From: Laura Gibbons
Sent: 17 April 2019 10:42
To: Planning.Responses
Cc: Daniel Vick
Subject: RE: Planning Consultation on: AL/32/19/OUT

Engineers Comments Regarding Surface Water Drainage

APPLICATION NO: **AL/32/19/OUT**

Site Address: Wings Nursery Lidsey Road Woodgate PO20 3SU

DRAINAGE STRATEGY

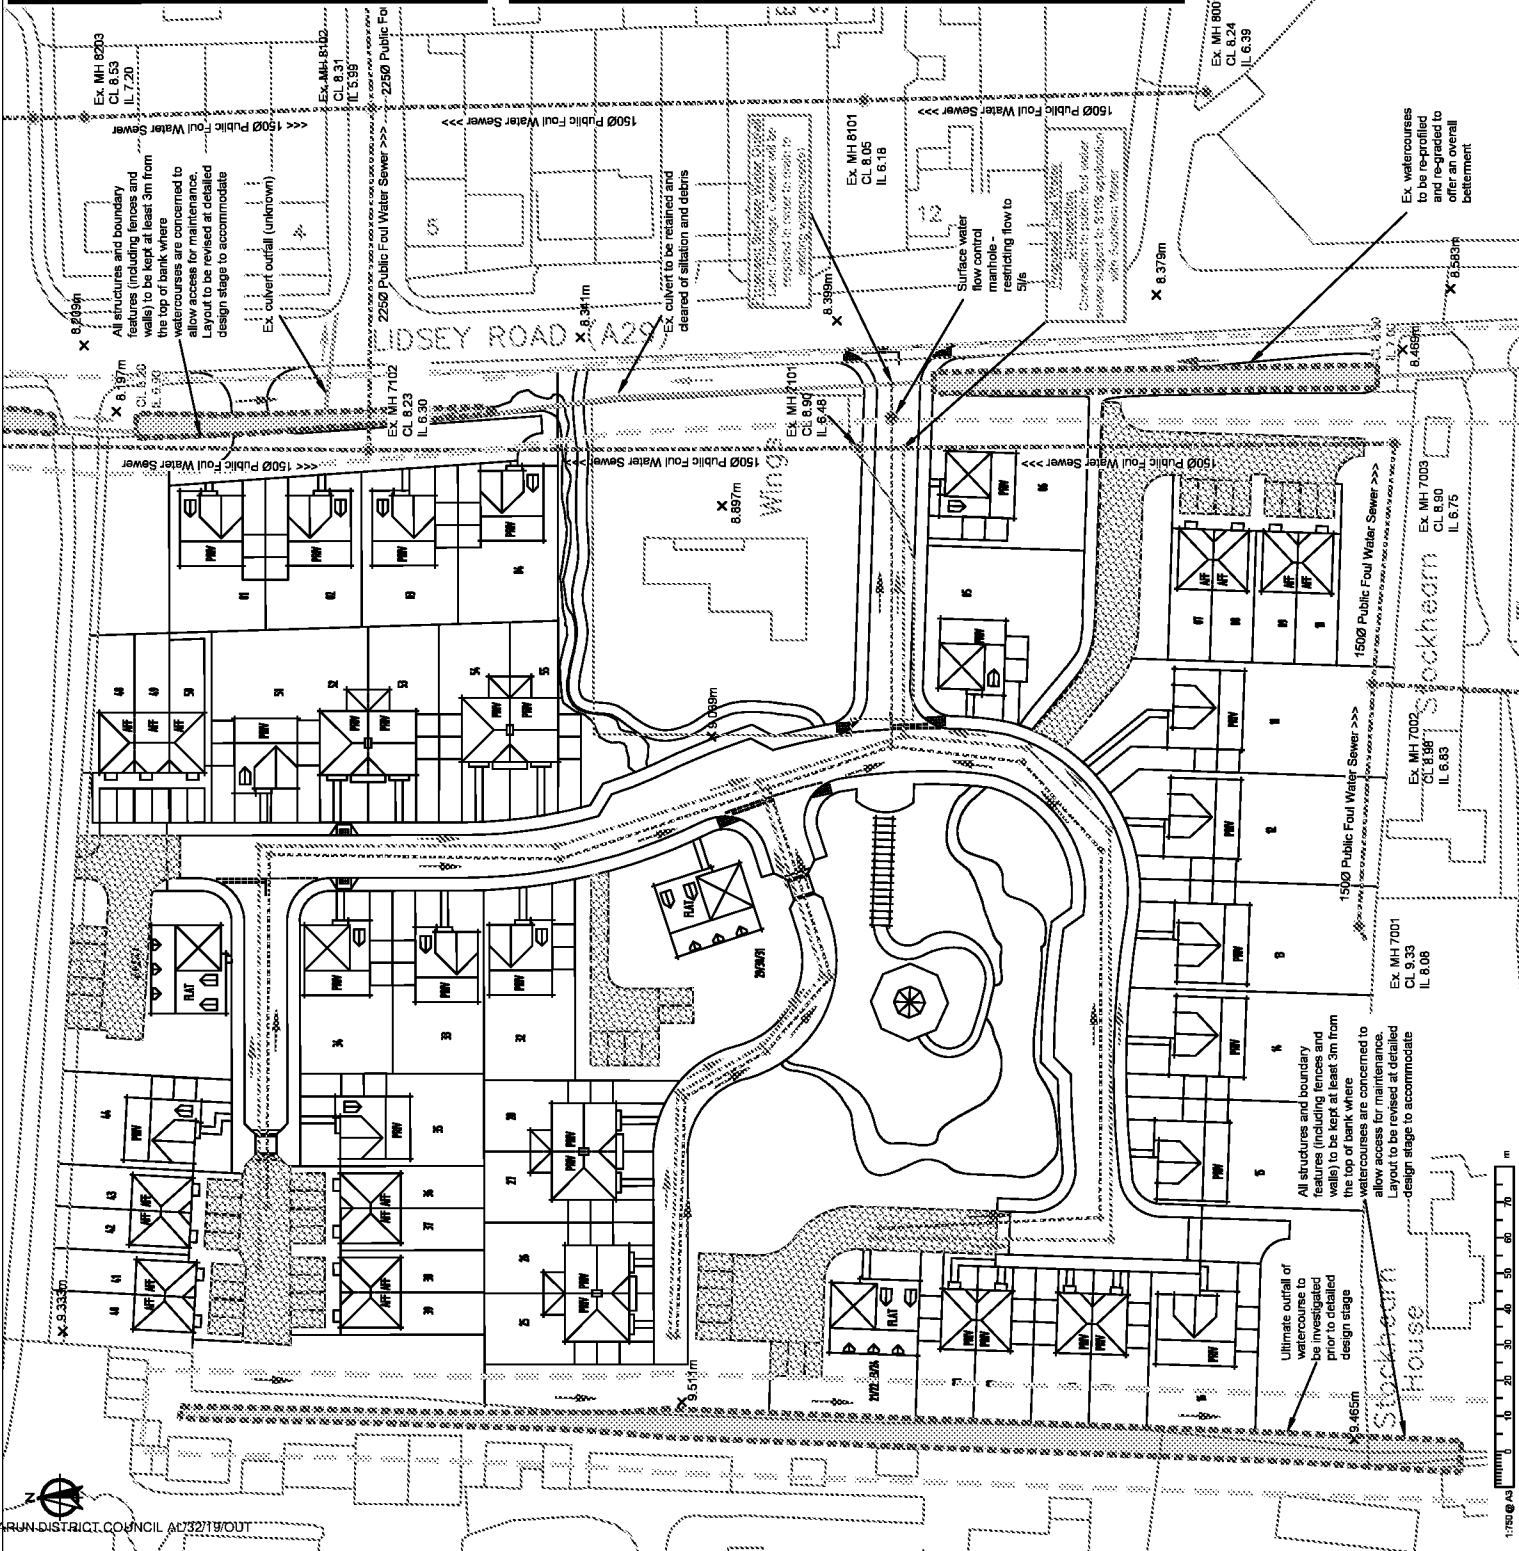
The application site has ordinary watercourses running along the eastern and western boundaries, easement to watercourses must be provided. Any proposed culverting to provide access would require consent. If discharge to watercourse is proved to be required it will need to be demonstrated that the downstream watercourse is in an appropriate condition to receive these flows.

The documents submitted in support of this application suggest that the proposed means of surface water drainage is through an attenuated discharge to a local watercourse. Infiltration testing must be completed to support the ruling out of infiltration, this infiltration testing should include testing at shallow depths appropriate for permeable paving.

If on-site infiltration is not possible, drainage via a restricted discharge to a suitable local watercourse may be acceptable. Any discharge should be restricted to greenfield QBar runoff rates.

Given the nature of the development, to bring it in line with current guidance, the documentation supporting the drainage design should be able to demonstrate that the infiltration/SuDS features can accommodate the water from a 1 in 100 year critical storm event, plus an additional 40% climate change allowance.

"Development shall not commence, other than works of site survey and investigation, until full details of the proposed surface water drainage scheme have been submitted to and approved in writing by the Local Planning Authority. The design should follow the hierarchy of preference for different types of surface water drainage disposal systems as set out in Approved Document H of the Building Regulations, and the recommendations of the SuDS Manual produced by CIRIA. Winter groundwater monitoring to establish highest annual ground water levels and winter Percolation testing to BRE 365, or similar approved, will be required to support the design of any Infiltration drainage. No building / No part of the extended building shall be occupied until the complete surface water drainage system serving the property has been implemented in accordance with the agreed details and the details so agreed shall be maintained in good working order in perpetuity."

"The development shall not proceed until details have been submitted to and approved in writing by the Local Planning Authority for any proposals: to discharge flows to watercourses; or for the culverting, diversion, infilling or obstruction of any watercourse on or adjacent to the site. Any discharge to a watercourse must be at a rate no greater than the pre-development run-off values. No construction is permitted, which will restrict current and future land owners from undertaking their riparian maintenance responsibilities in respect to any watercourse or culvert on or adjacent to the site."
